LU/65/18/L

5 River Road is an attractive three storey semi-detached property, which is located in the heart of the Conservation Area. A significant amount of work has been undertaken to the property by the current owners which has ensured that it remains in a good state of repair.

The current proposal is to undertake works to the roof on an outbuilding. This involves the repair of an existing slate roof and replacement a section of a felt flat roof. Such a proposal is considered to be acceptable in principal as it involves an element of repair, as well as that of enhancement.

CROSS-SECTION OF SHEDS

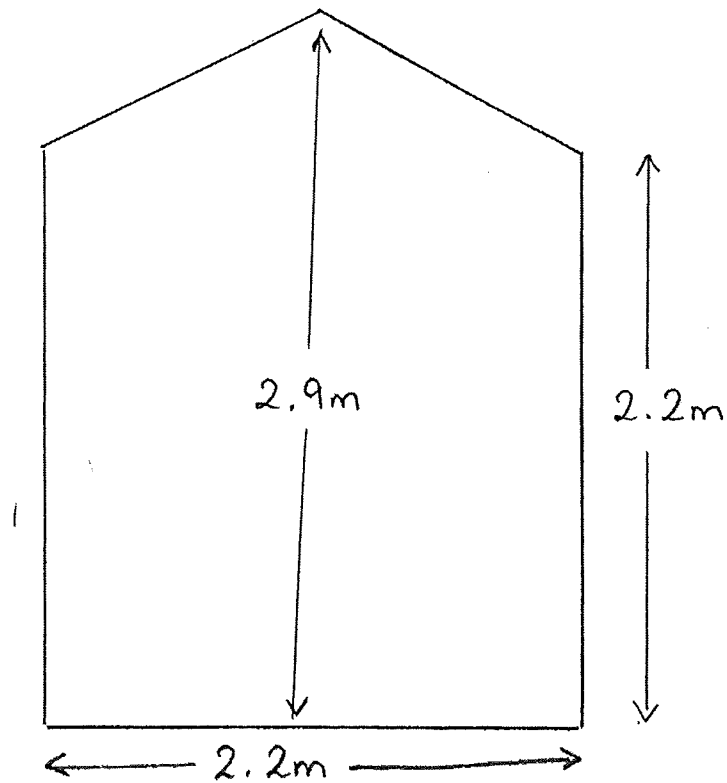
The problem with the application is that the level of information provided is not sufficient to fully assess the impact of the proposal. For example, simple hand drawn elevations are provided along with what appears to be a standard picture of a timber framed roof. This does not allow us to clearly identify what the new roof structure will look like and raises a number of questions, including what will the eaves detailing look like etc.?

Further information would be required to fully assess the impact of the proposal before an opinion can be provided.
